El Paso County, Colorado,

In response to review comments made on July 14, 2022:

Tower Engineering Professionals, OPCO. (TEP)
Geoffrey McDaniel
Project Manager - Phoenix

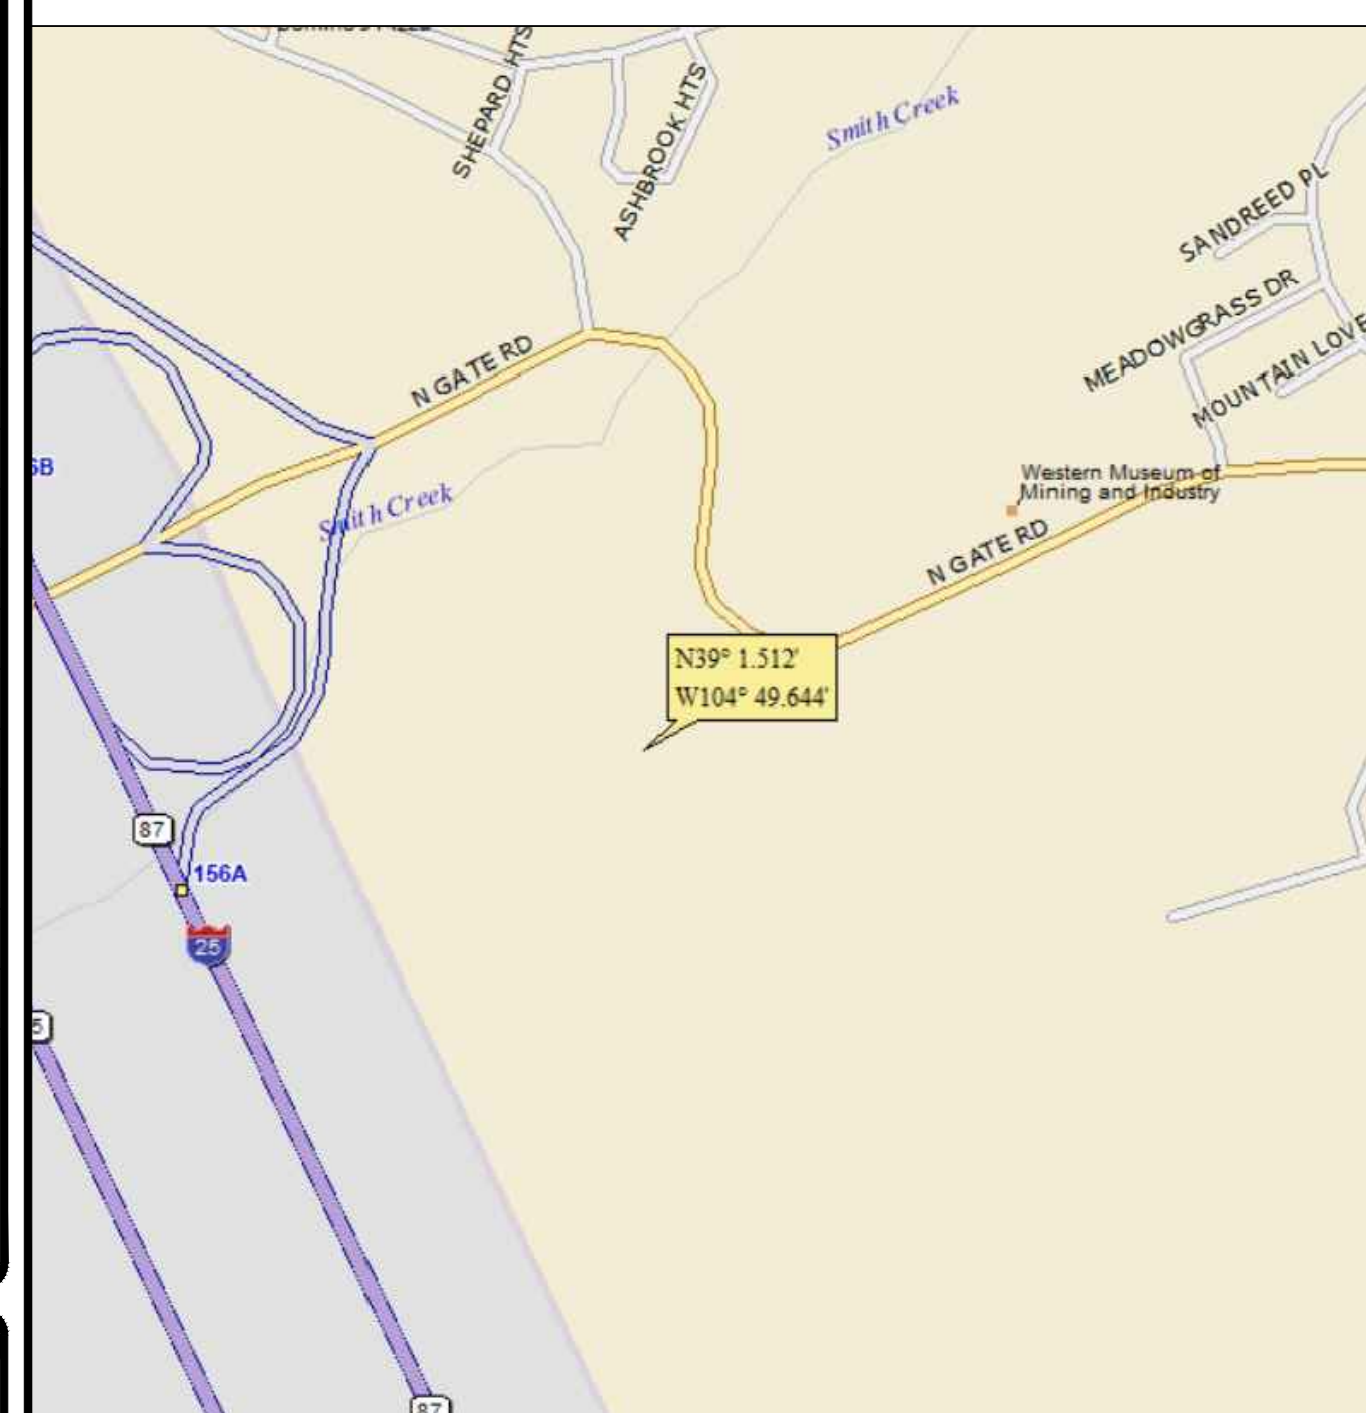
1. Please include a legal description of property (found on assessor site)

Legal description from assessor site added and clouded in the applicable codes/reference documents section on sheet T-1.

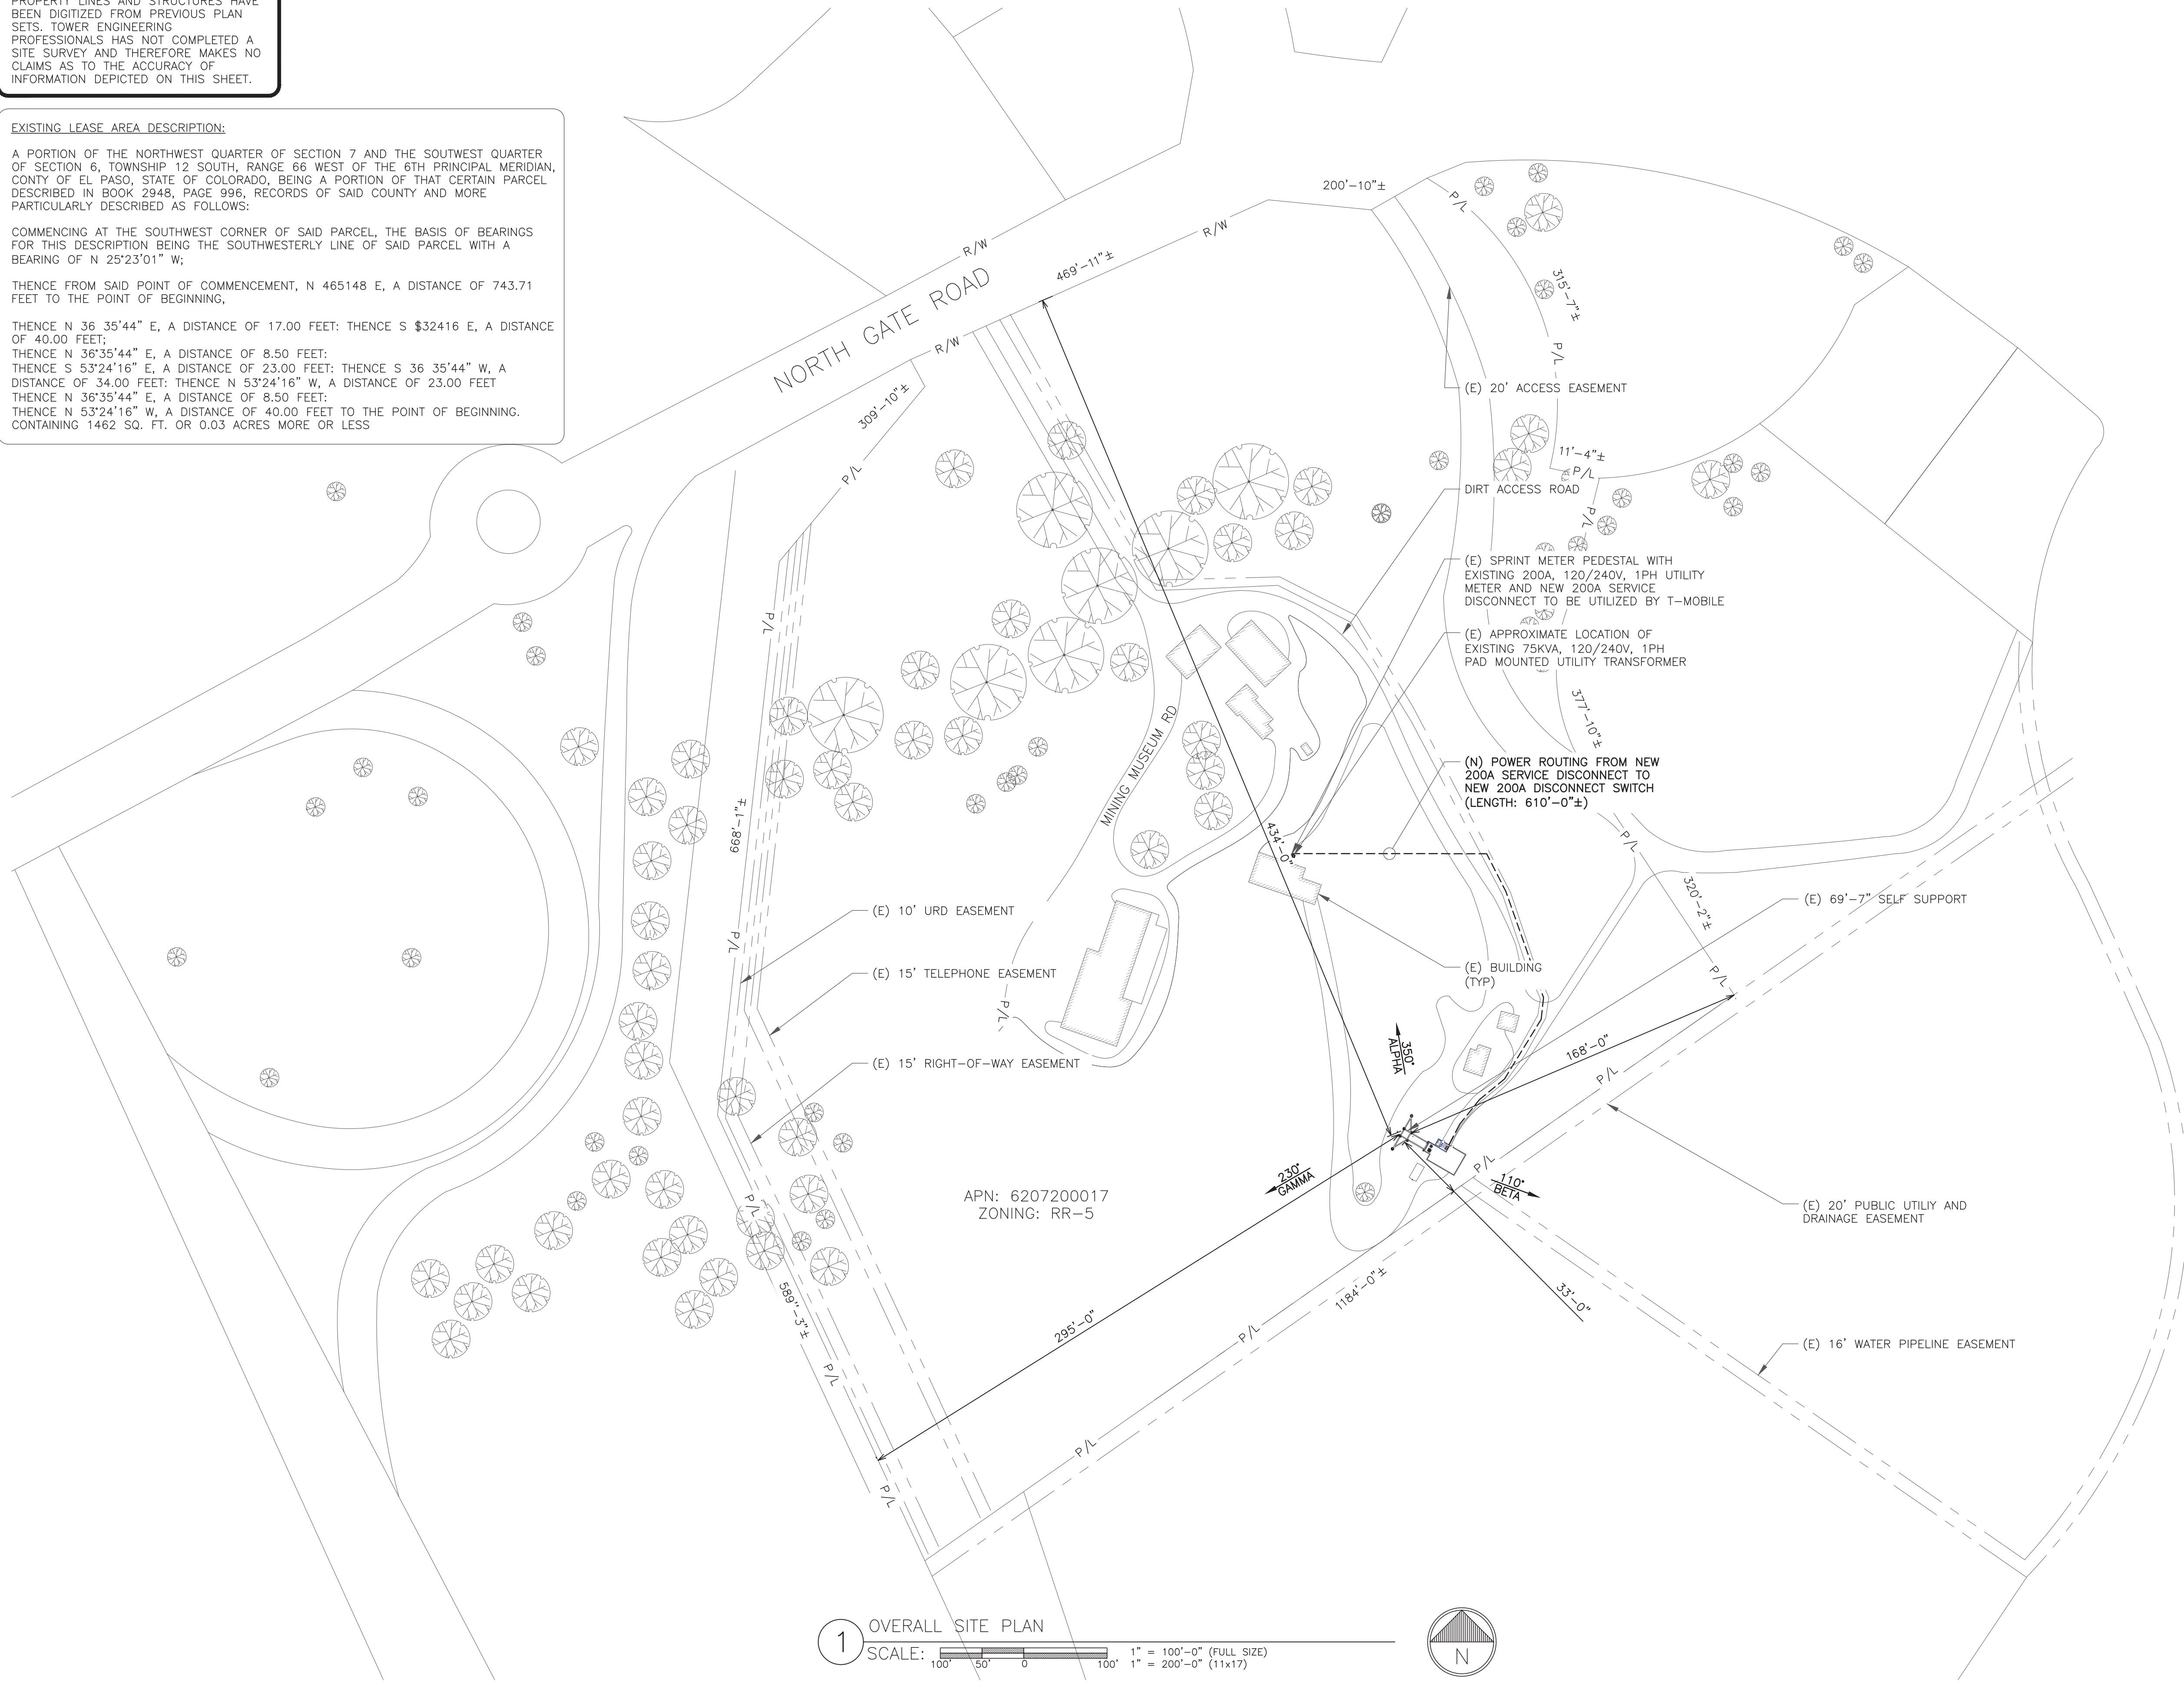
2. Please include lot/parcel size.

Sheet C-1.1 has been updated to include the full parent parcel, setback dimensions from the tower to the property lines, and length dimensions at each section of the parcel lines. Legal description of current lease area added to the top left corner of sheet C-1.1. Sheet C-1.1 has been clouded to show where the changes occurred.
